ELIZABETH VILLAGE
 HAWTHORNE LANE
 CHARLOTTE
 THE CONFORMITY CORPORATION

DATE: NOVEMBER 15, 2001
 PROJECT: 99-2001
 SCALE: 1" = 20'
 JANUARY 8, 2002
 FEBRUARY 1, 2002
 FEBRUARY 15, 2002
 MARCH 8, 2002
 JUNE 7, 2002 - REV. BUILD TO LINE

DATE: June 18, 2002
 FROM: Martin R. Cramton, Jr.
 Planning Director
 TO: Robert Brandon
 Zoning Administrator

SUBJECT: Administrative Approval for Petition No. 2001-139 by Monte Ritchey.

Technical Data Sheet

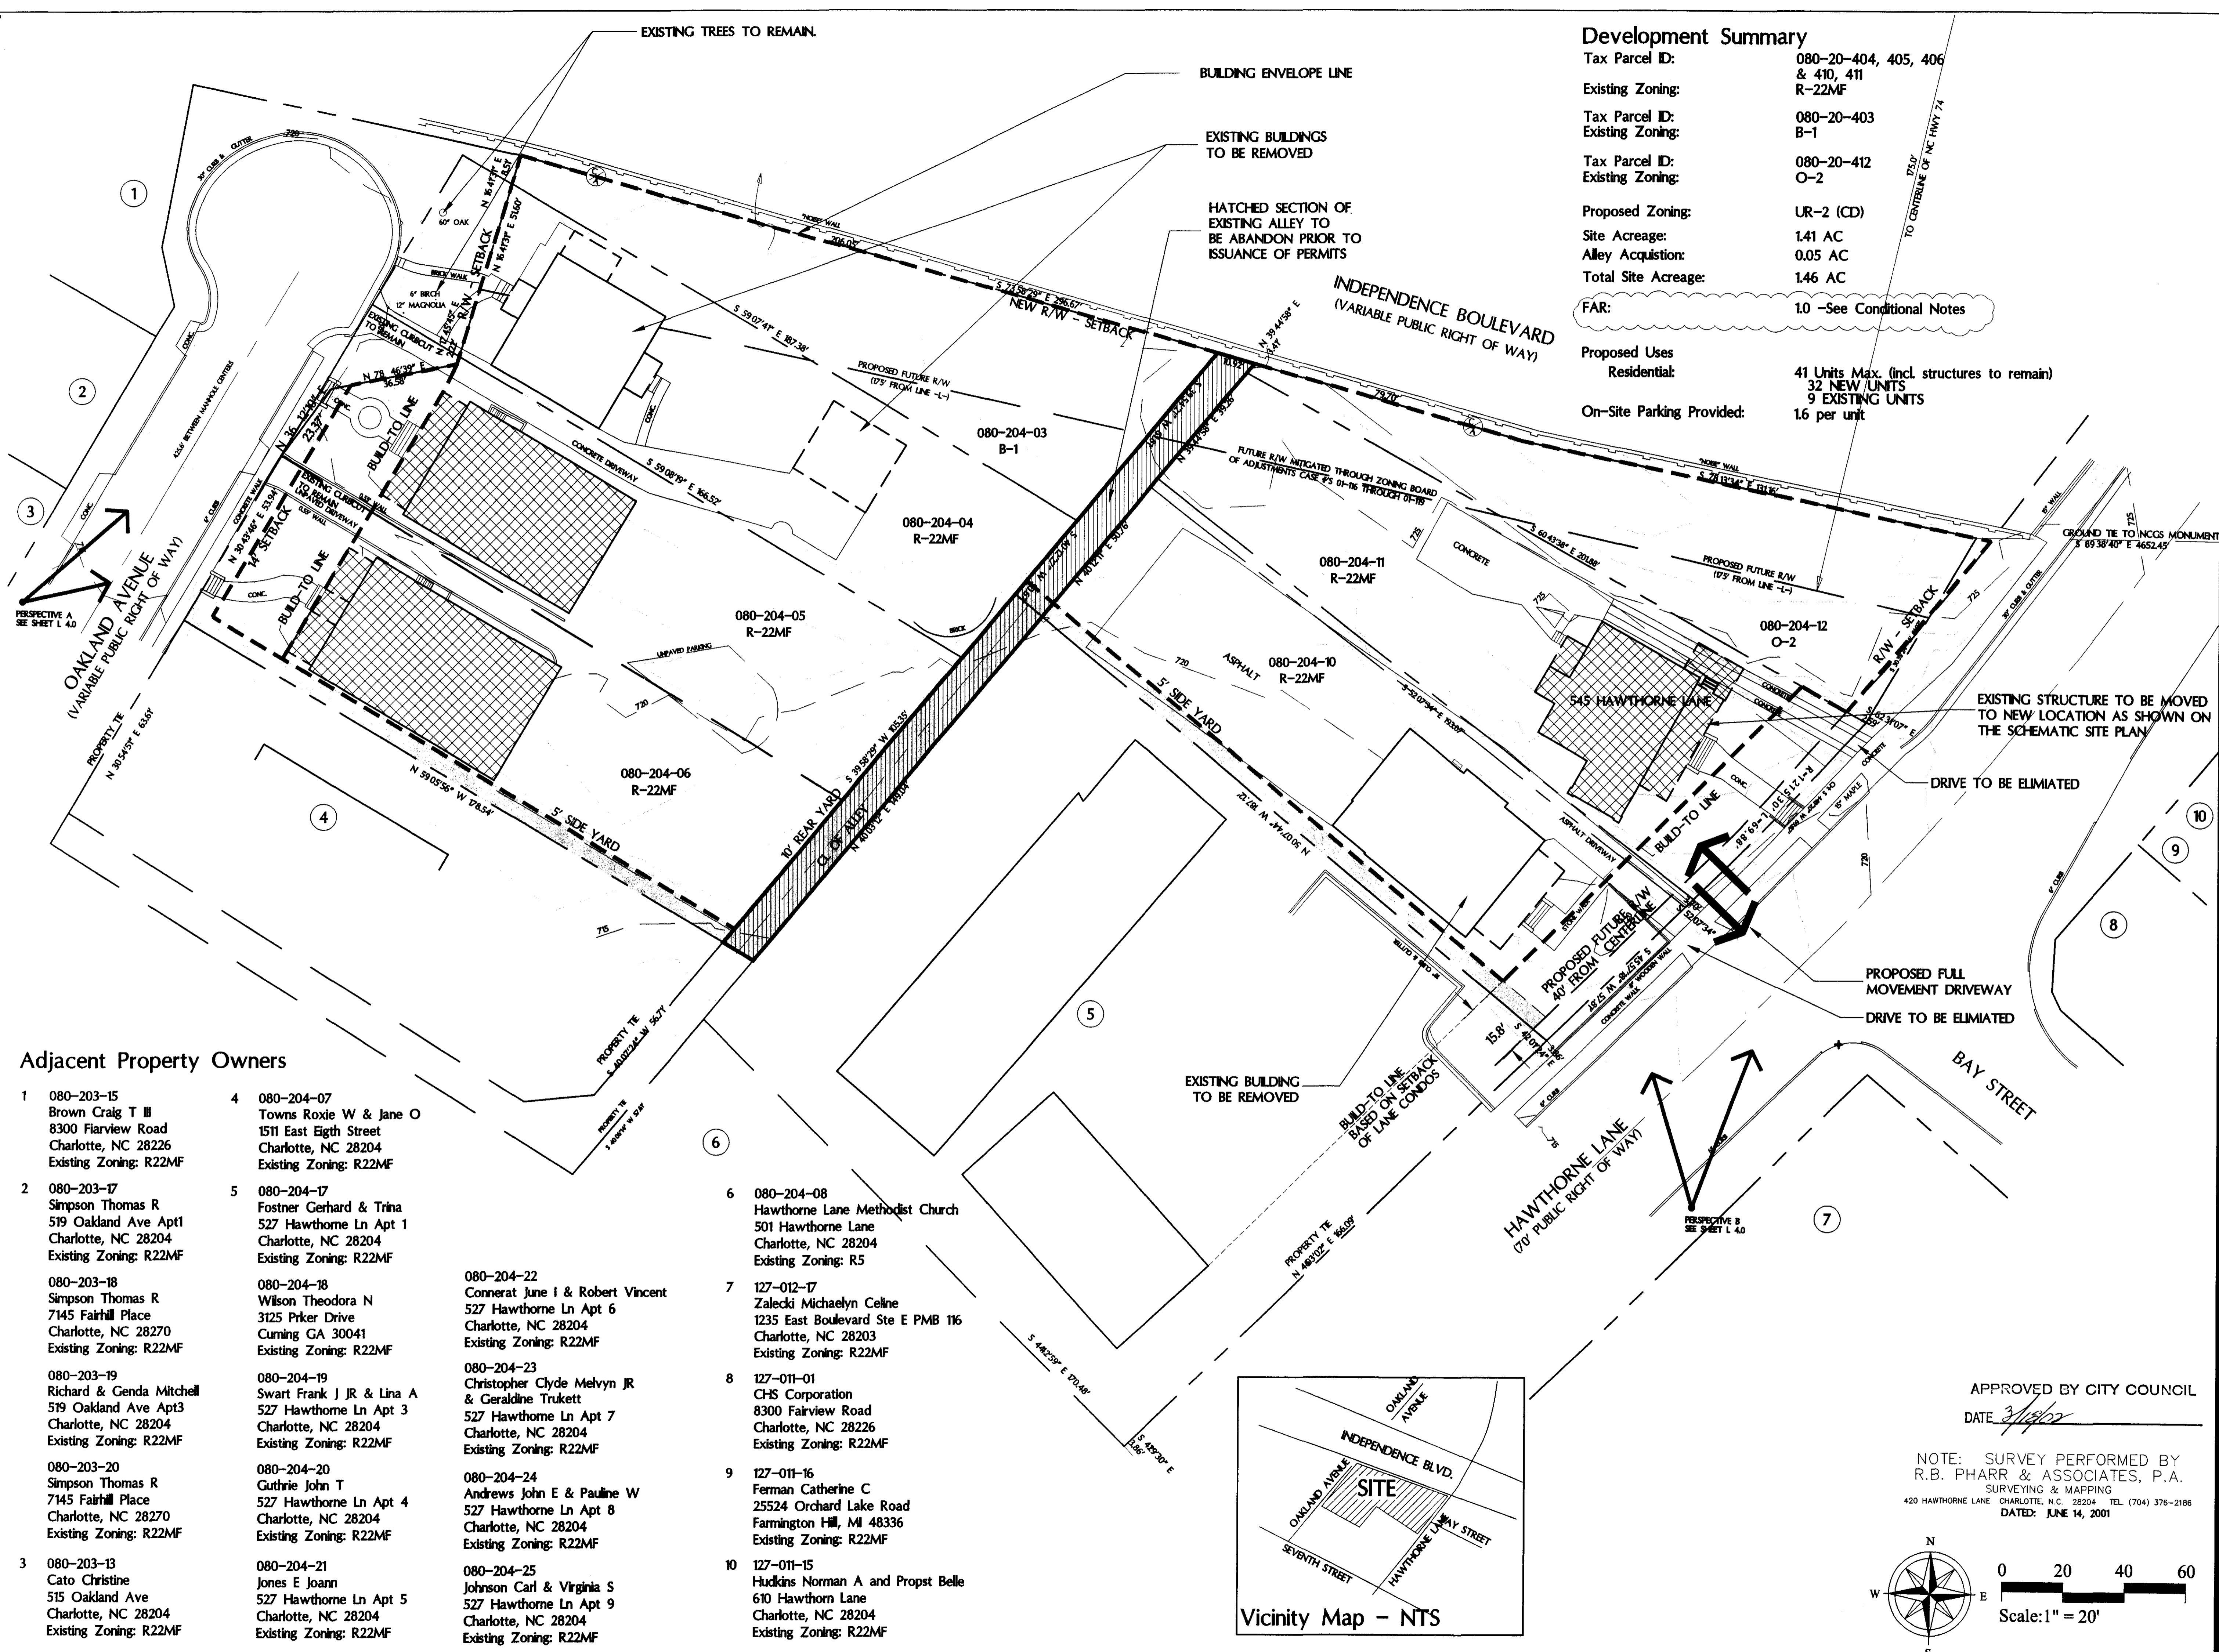
Attached is a revised plan sheet L1.0 for the above petition. This plan has been revised to clarify the setback to match sheet L.3.0. Since this clarification is minor, I am administratively approving this revised sheet. Please note that sheets L2.0, 3.0 and 4.0 from the original approval still apply. Please use this plan when evaluating requests for building permits and certificates of occupancy.
